### Search application details

| Application number: 2026/CLD/91870/W |                                                                                  |
| What is the application for?:        | Certificate of lawfulness to convert dwelling to residential institution childre |
| Address of the site or building:     | 14, Howard Avenue, Lindley, Huddersfield, HD3 3DJ                                |

Existing Site Plan

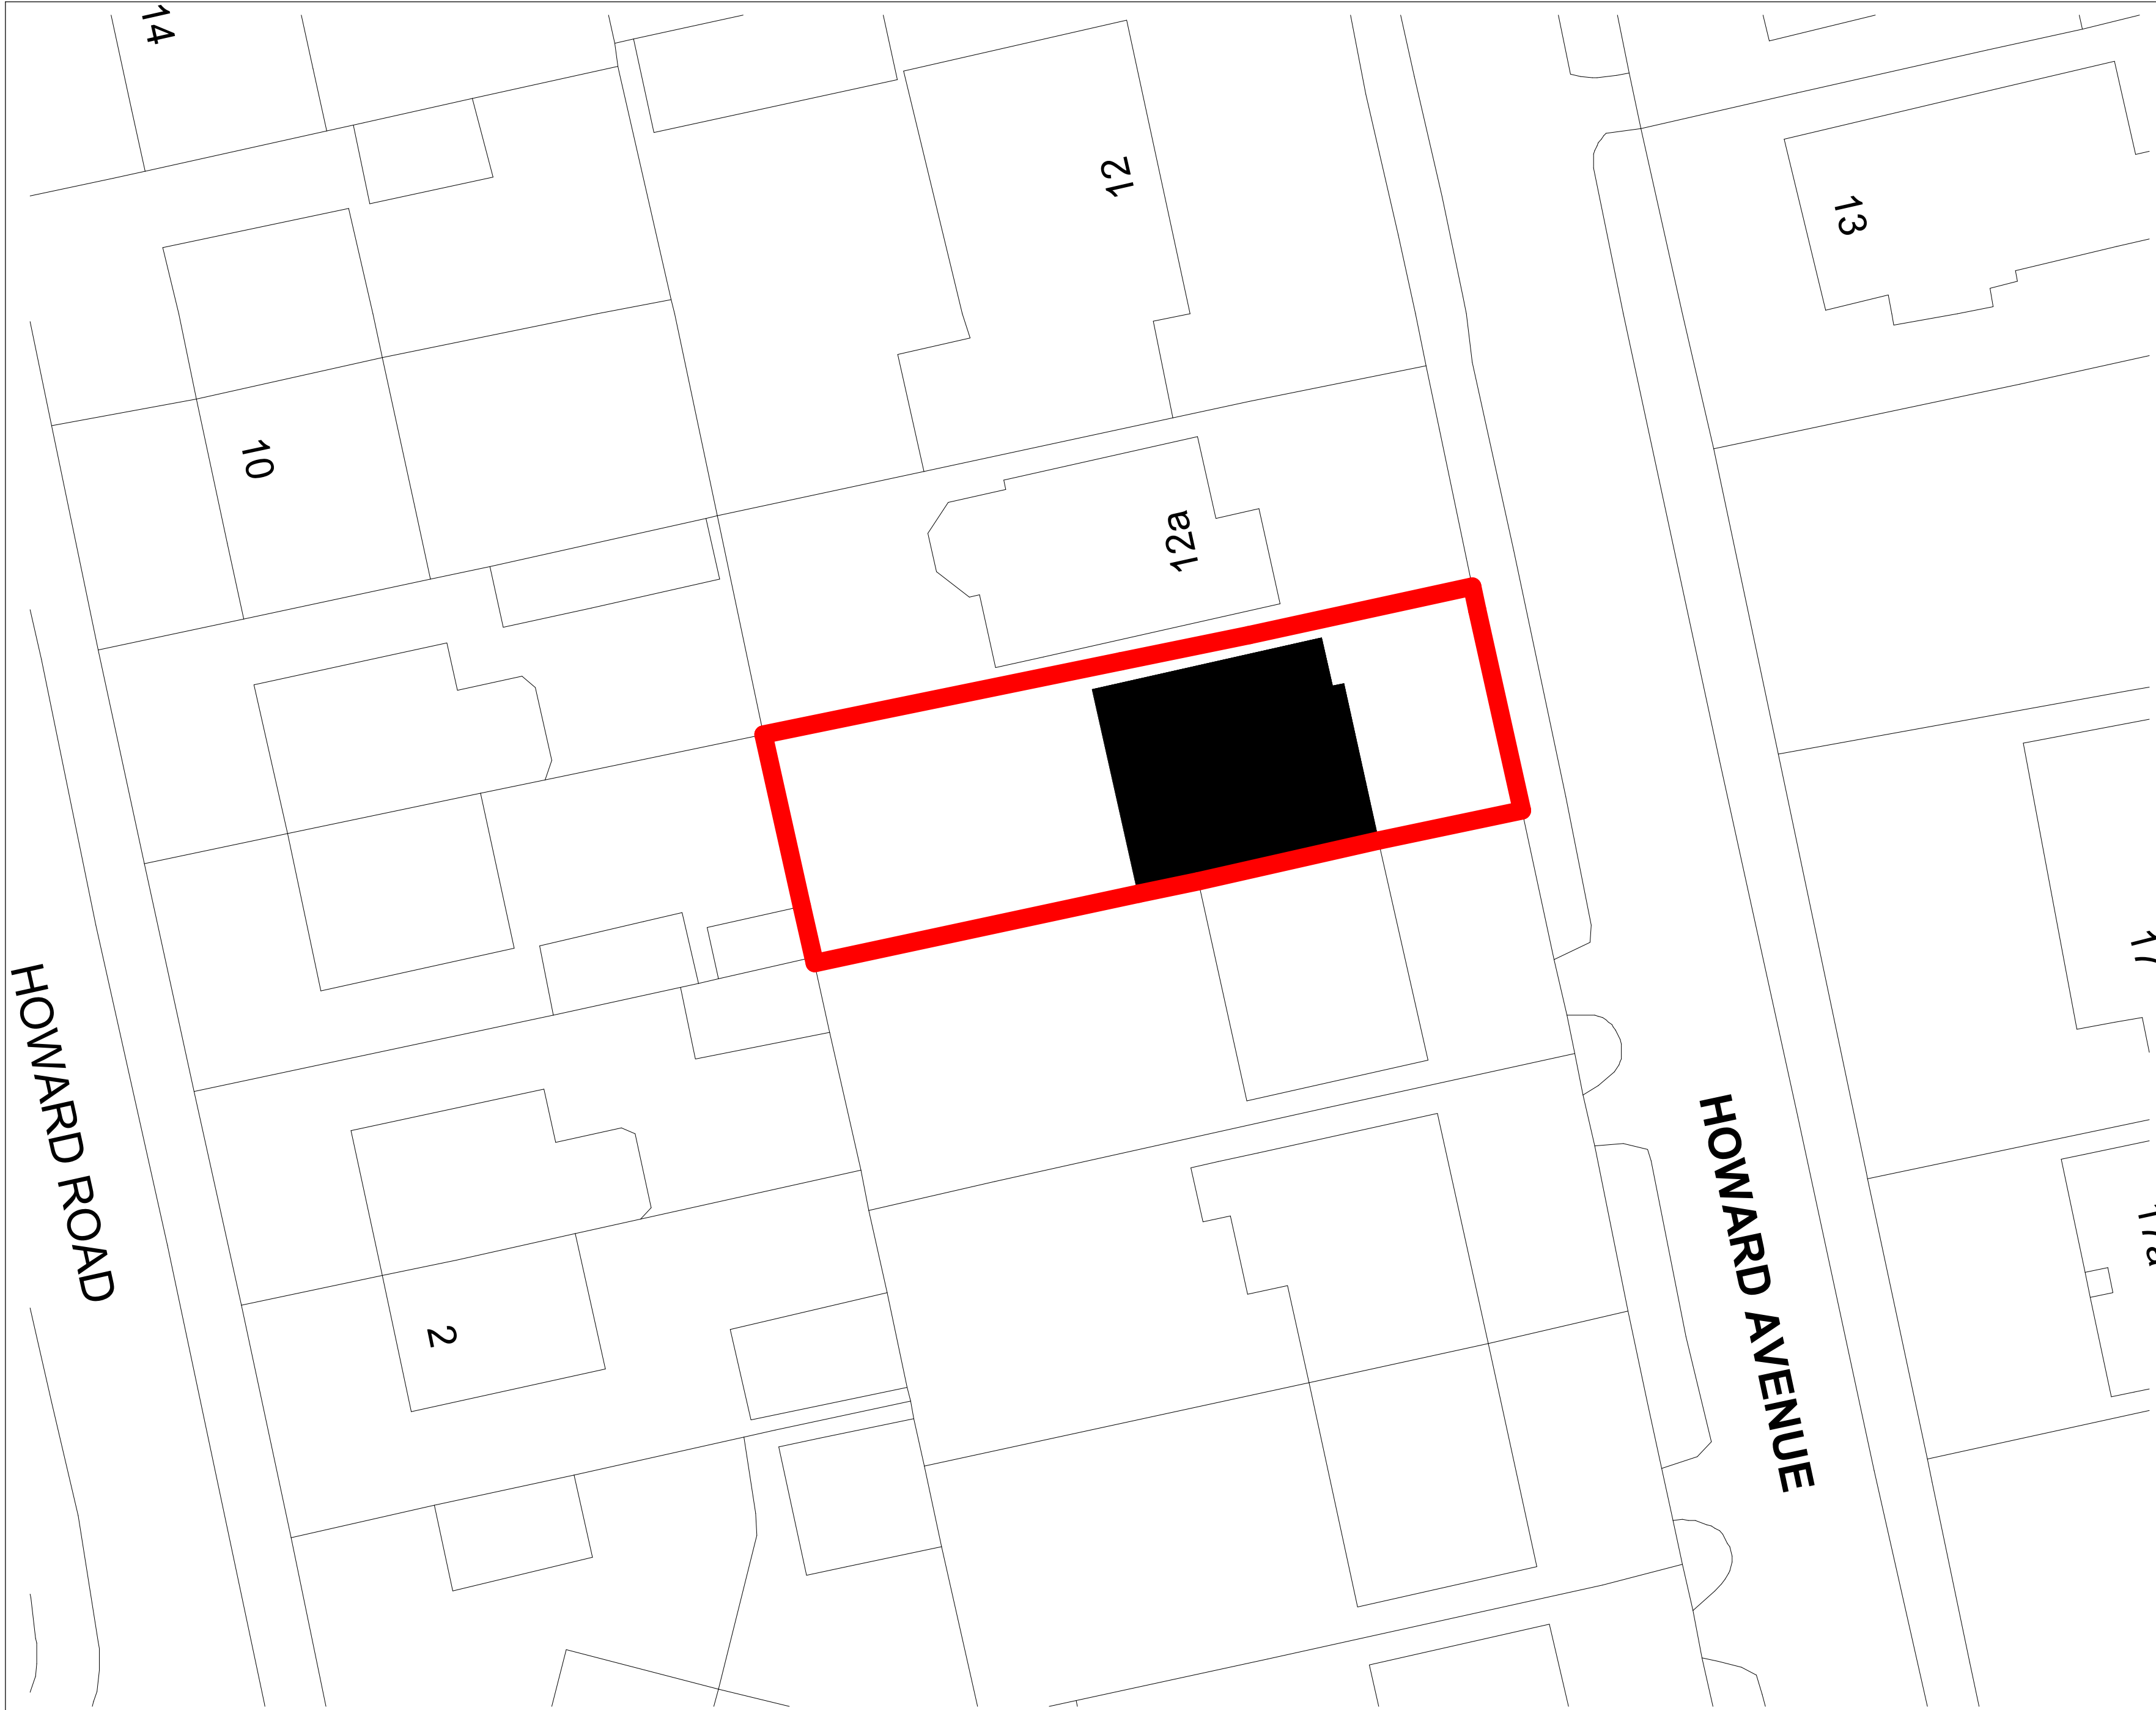
It claims 3 parking spaces, but only 2 are safely usable. The third restricts access and is not practical. No evidence is provided to prove 3 spaces exist.

Khuram	
14 Howard Avenue, Huddersfield	
Proposed Floor Plan	
Project number	RAD-35-26
Date	20.05.2026
Drawn by	RA
Checked by	RA
20	
Scale	1 : 50

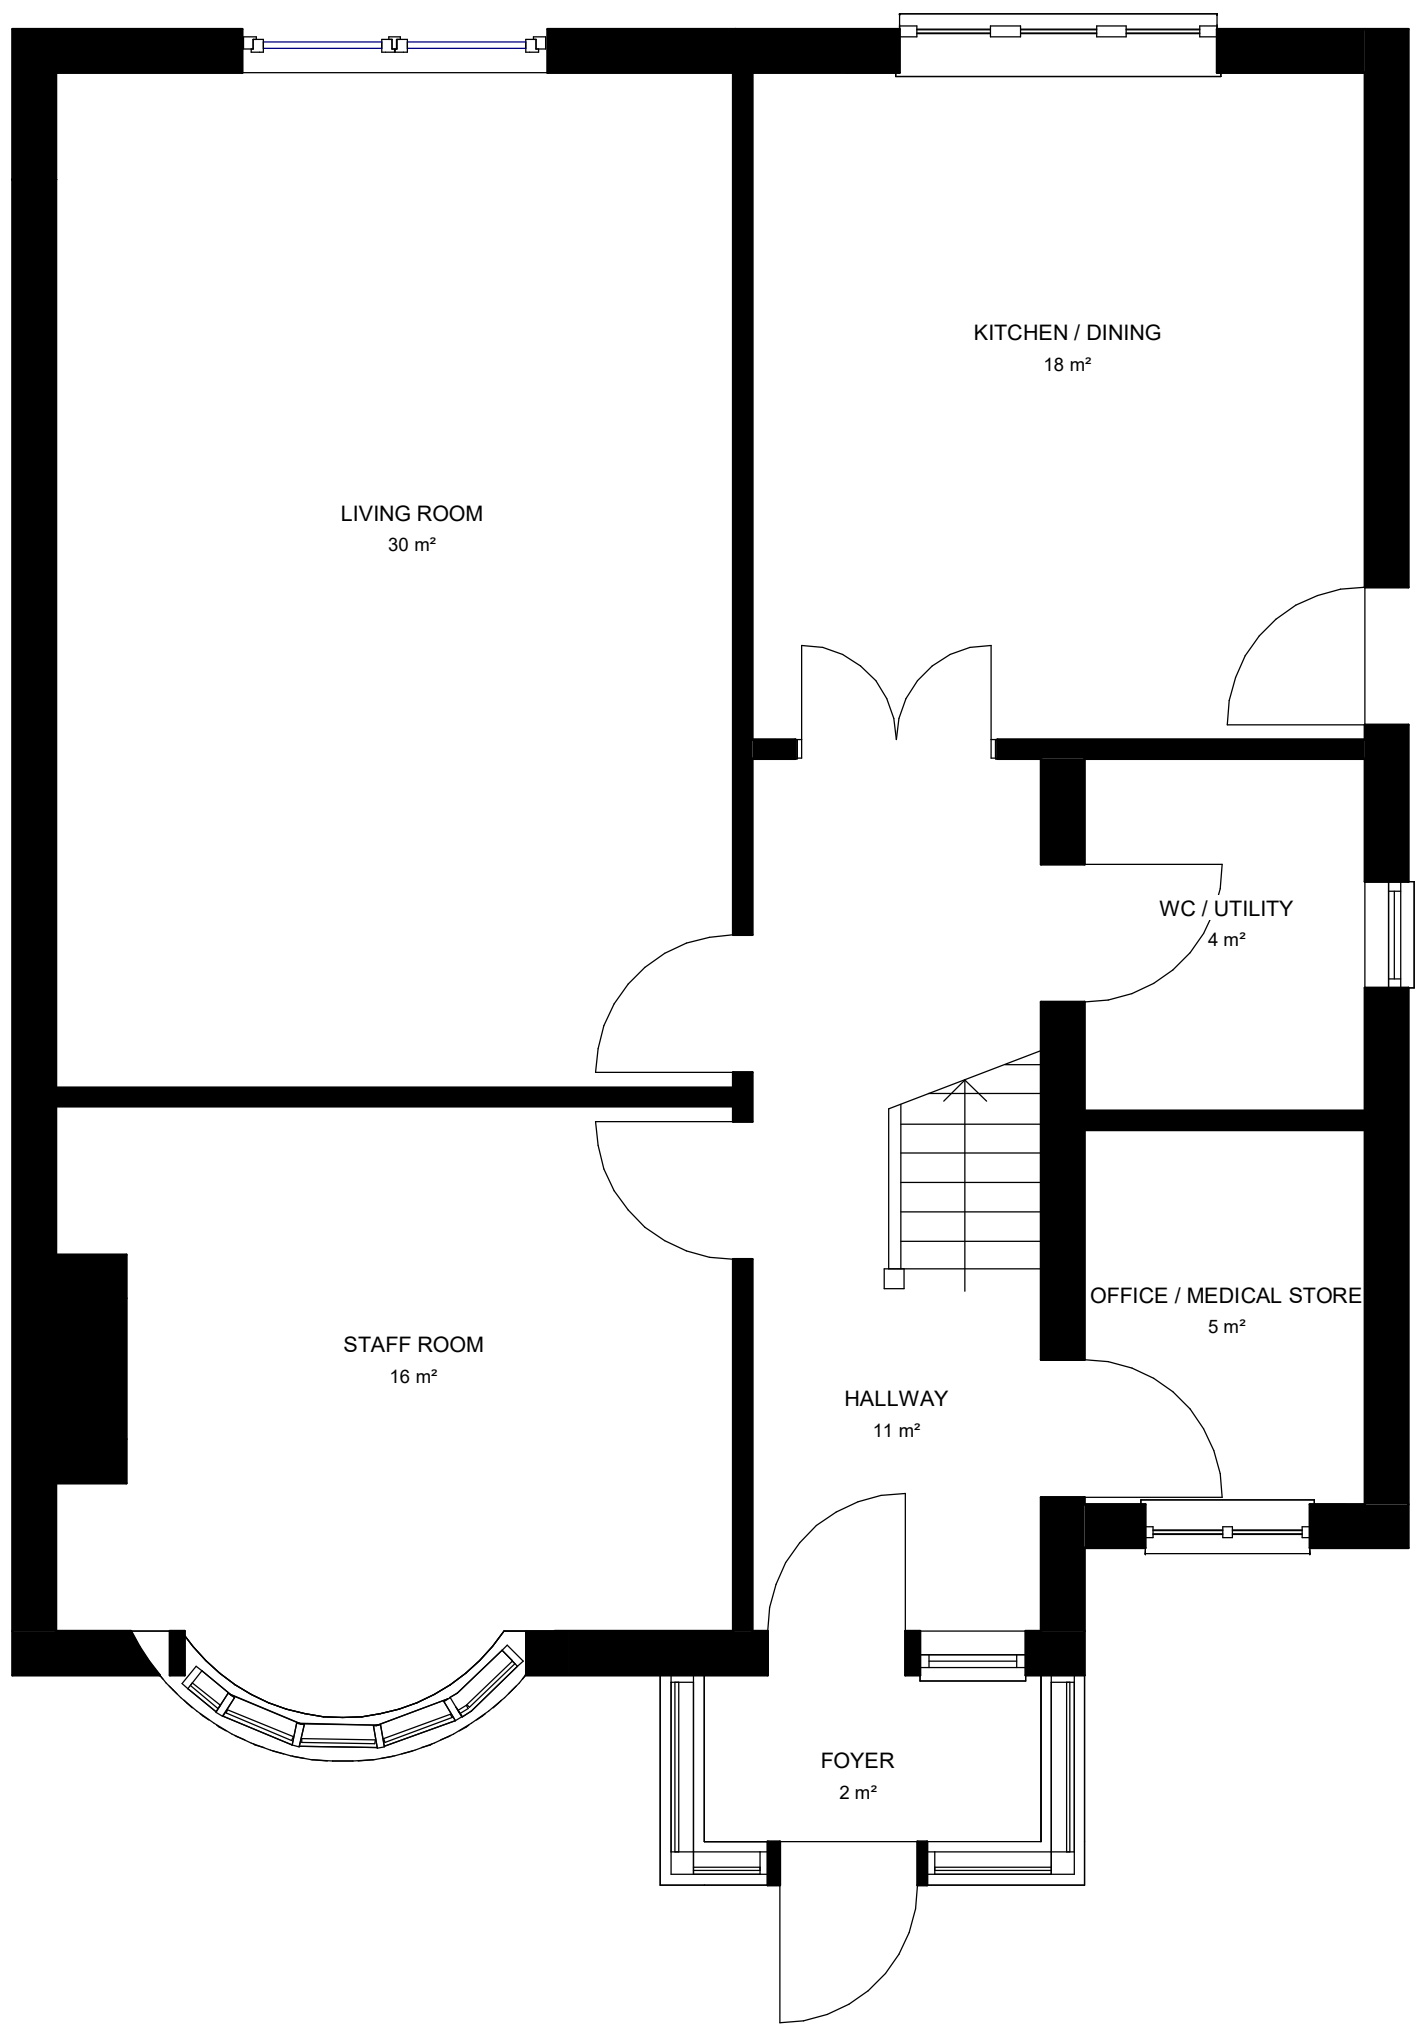
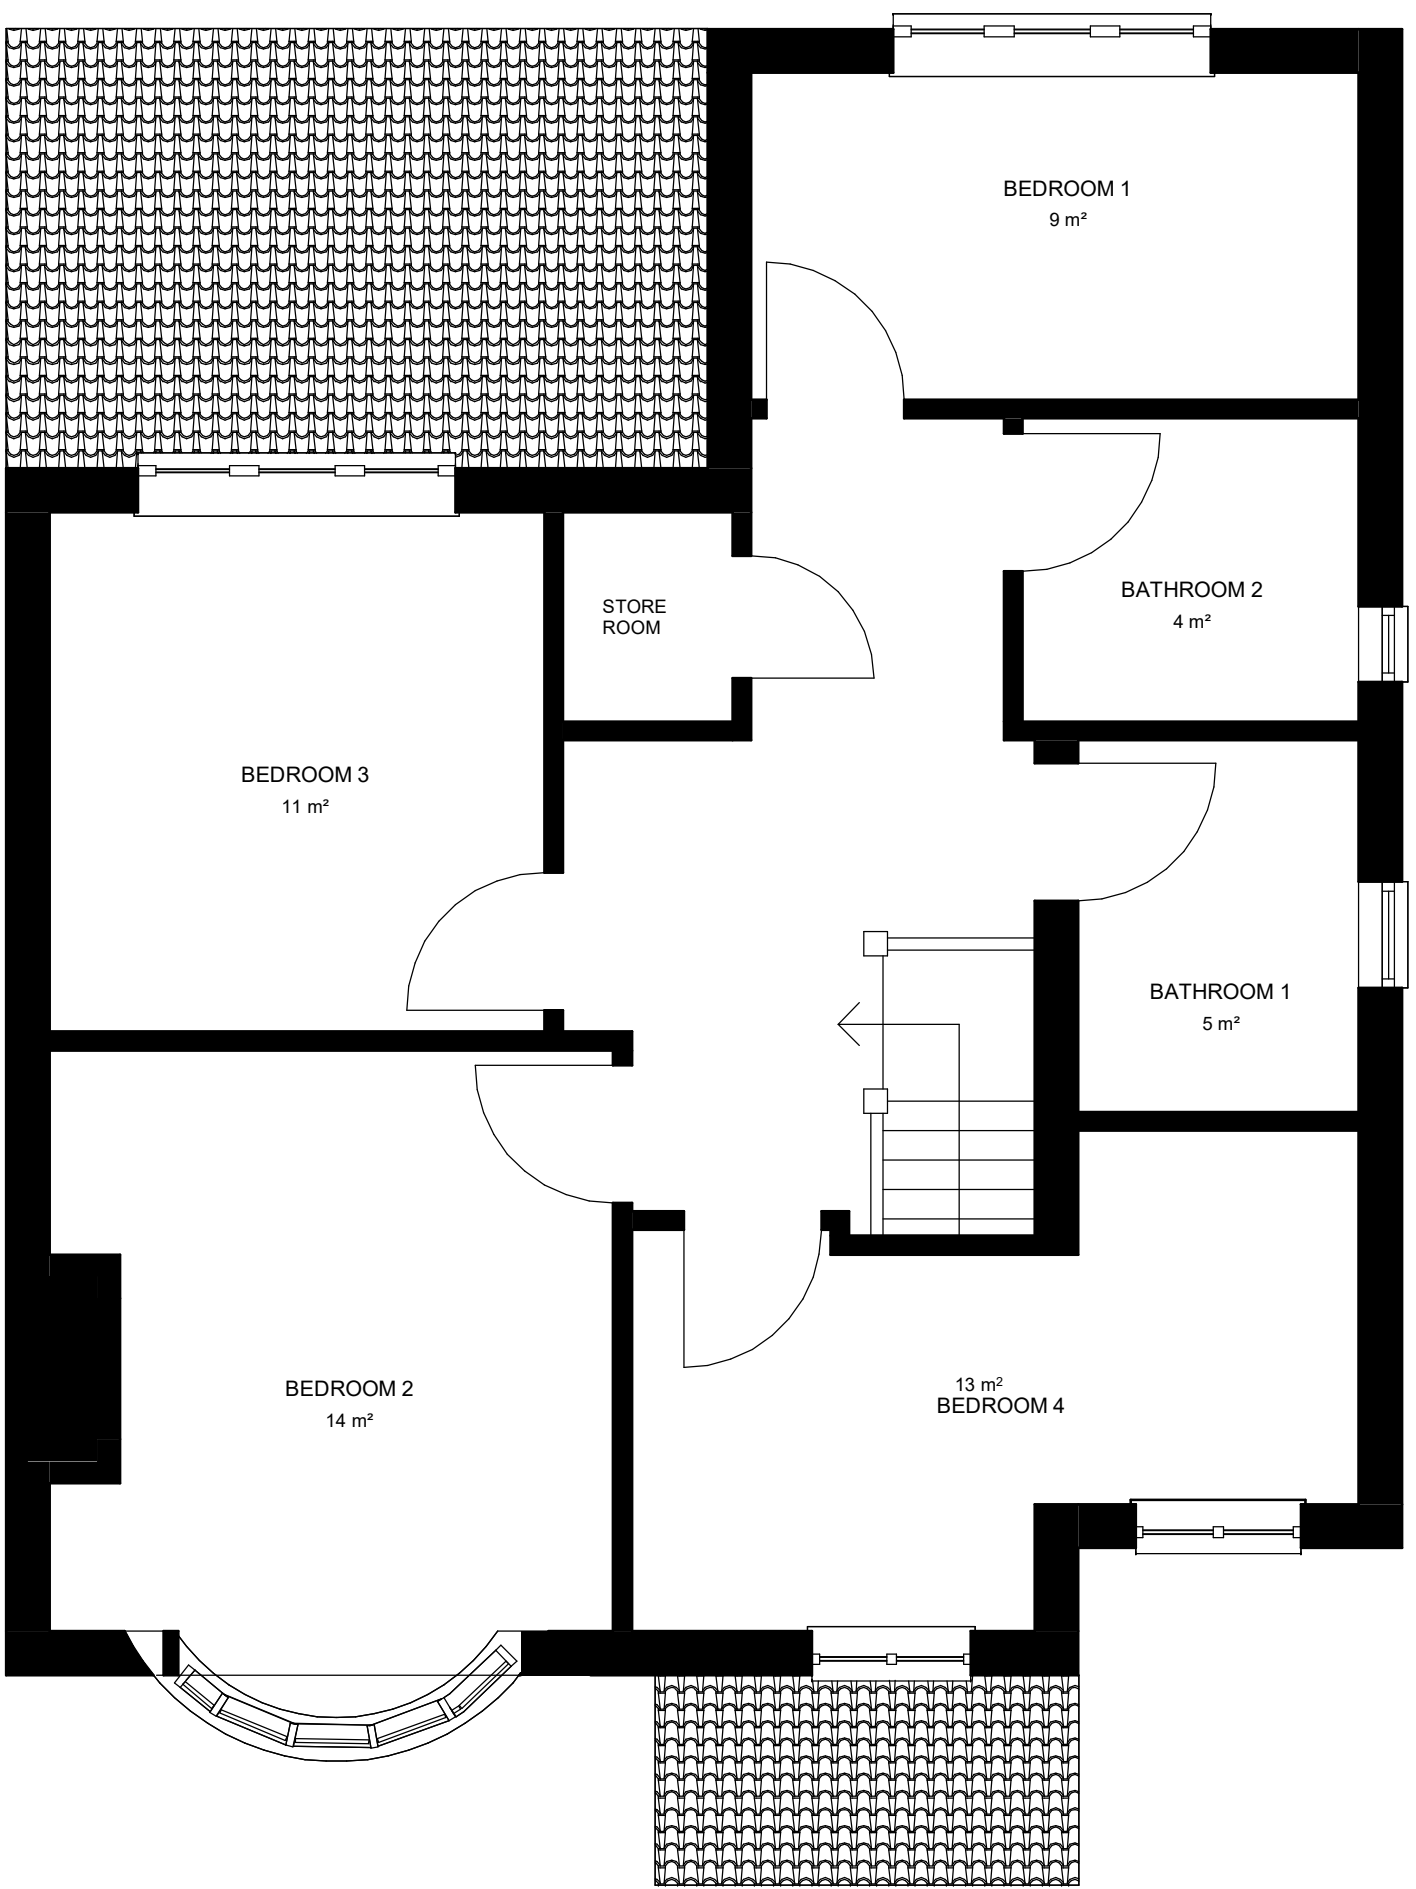
Plans include staff rooms, offices and medical storage. This is not just a private house – it is a managed care establishment that should go through full planning permission, not this certificate route.
